DRB Application No.: **05DRB-00309 (P&F)**

Project Name: **LANDS OF CHARLES & THERESA LUCERO**

**March 2, 2005  
DRB Comments**

**RE: LANDS OF CHARLES B. & THERESA M. LUCERO/ minor  
plat**

**SKETCH OF
LOTS A AND B
LANDS OF CHARLES B. AND THERESA M. LUCERO
ALBUQUERQUE, BERNALILLO COUNTY, NEW MEXICO
FEBRUARY 2005**

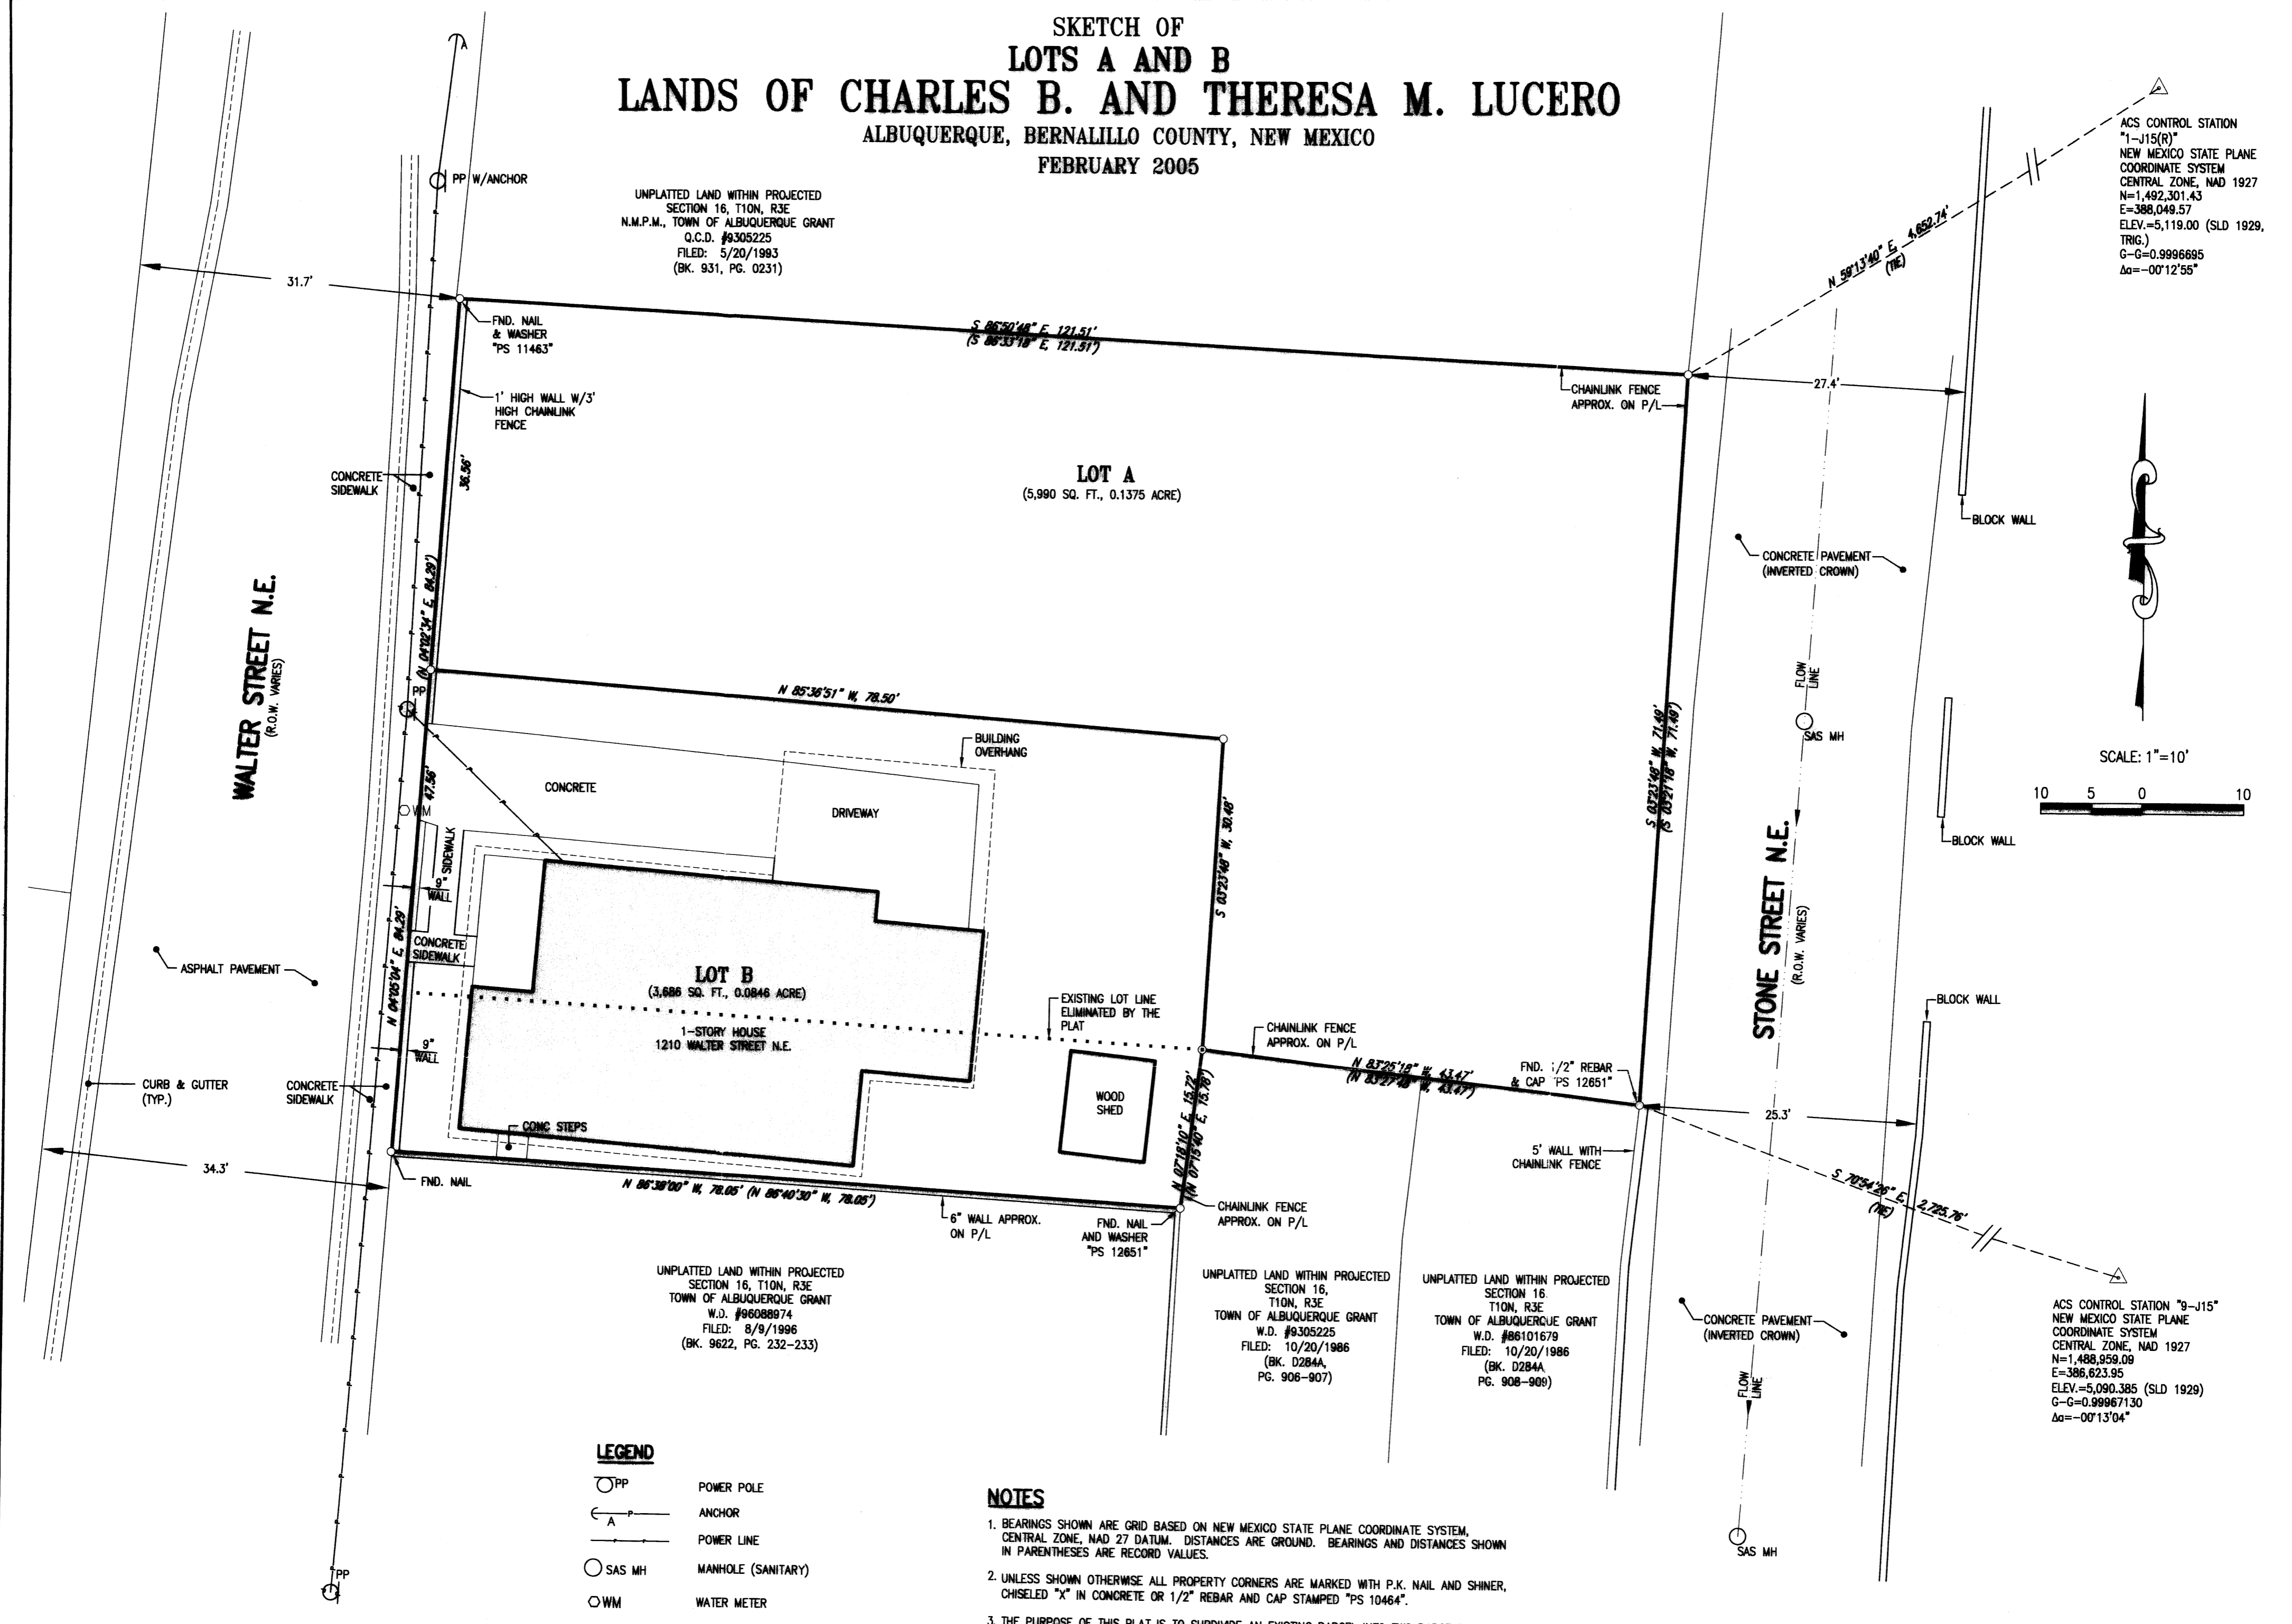
The existing residence on lot B must meet the required setbacks for R-T wherever there is new line proposed. The front yard setback is 15 feet with a driveway not less than 20 feet. There is no side yard setback requirement. There shall be a distance of not less than 10 feet between residential buildings.

If the residence was constructed prior to 1959 and the owner has proof of this construction date, then the nonconforming front yard setback and the 10 foot separation between residences are allowed without a variance. Otherwise, a variance is required.

Planning can take delegation on the plat until the variance request is heard. If approved, Planning will sign the plat. If not approved, the plat will not be signed or recorded.
